Holmbury , Lombard Street, Shackleford, Surrey, GU8 6BH

Proposed Bespoke ancillary annex for use by disabled person

Permission reference 22/P/01436 Proposed Non-material amendment

Revised Block Plan 1:500

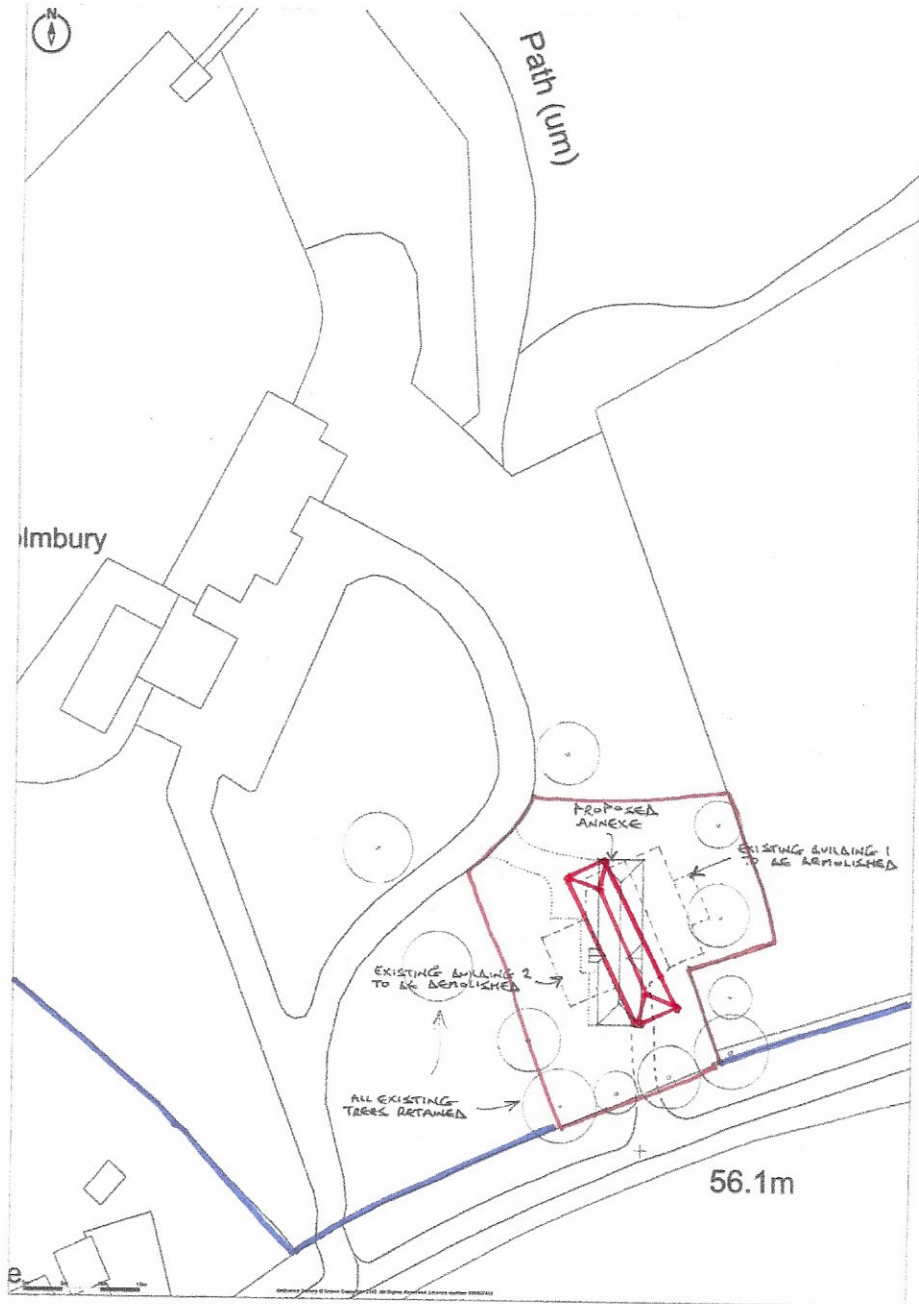
Ground levels suggest that a slight re-orientation of the approved building will reduce excavation and fill and speed up construction. It will also turn the annex slightly to reduce potential for over-looking from the host dwelling. There is no movement of the annex, as it will pivot on its proposed axis and will remain in the location between the two structures that are to be removed. There will consequently be no Green Belt impact.

SET-OUT LAYOUT

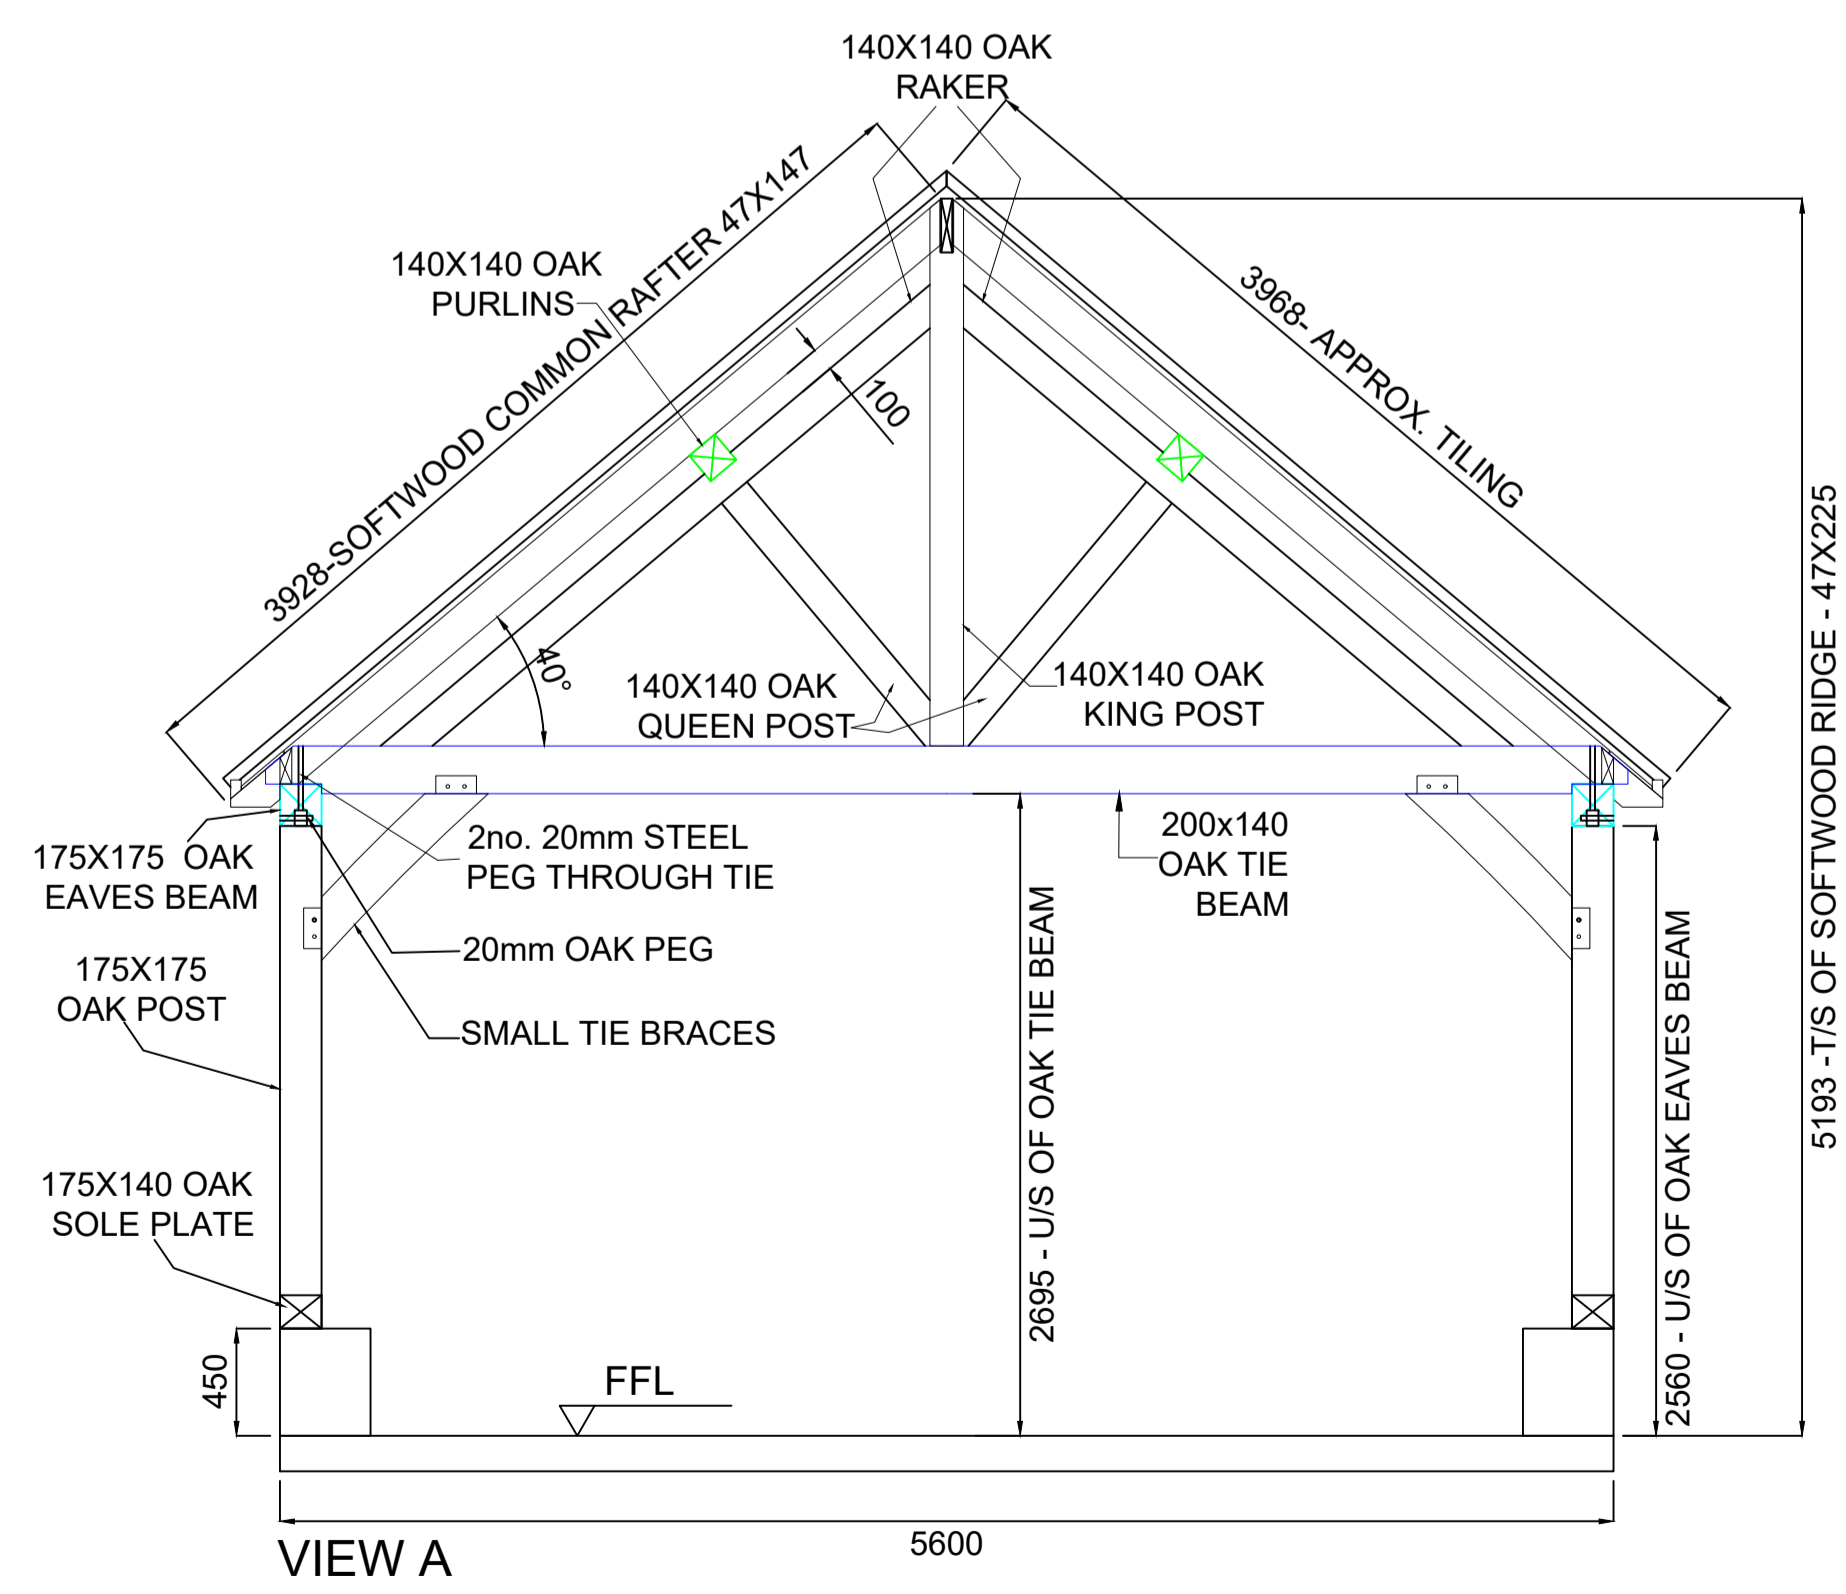
Prior to construction it has been found that the hoist system required cannot be accommodated within the approved ceiling heights. It is a ceiling track hoist based on an H system meaning that there is inadequate cross beam height within the approved scheme. The track system runs through all rooms continuously offering the occupant the option of a walking sling to access all rooms and parts of the building. To keep the height as approved, removes this option and would provide a separate track in each room and not one that is continuous.

In addition, the occupant is 6ft 2in and he must have enough head height to allow him to be raised in and out of his wheelchair, standing frame, Gait Trainer, bed and changing bed. The increase in head height will allow flexibility as to where the occupant can be hoisted into these movement aids.

The increase in height required is 45cms and it is proposed this is achieved by inserting that height of brickwork or blockwork at the base of the building and placing the approved scheme on top. The brickwork could remain exposed or, as preferred by the applicant, timber cladding will extend to ground level.
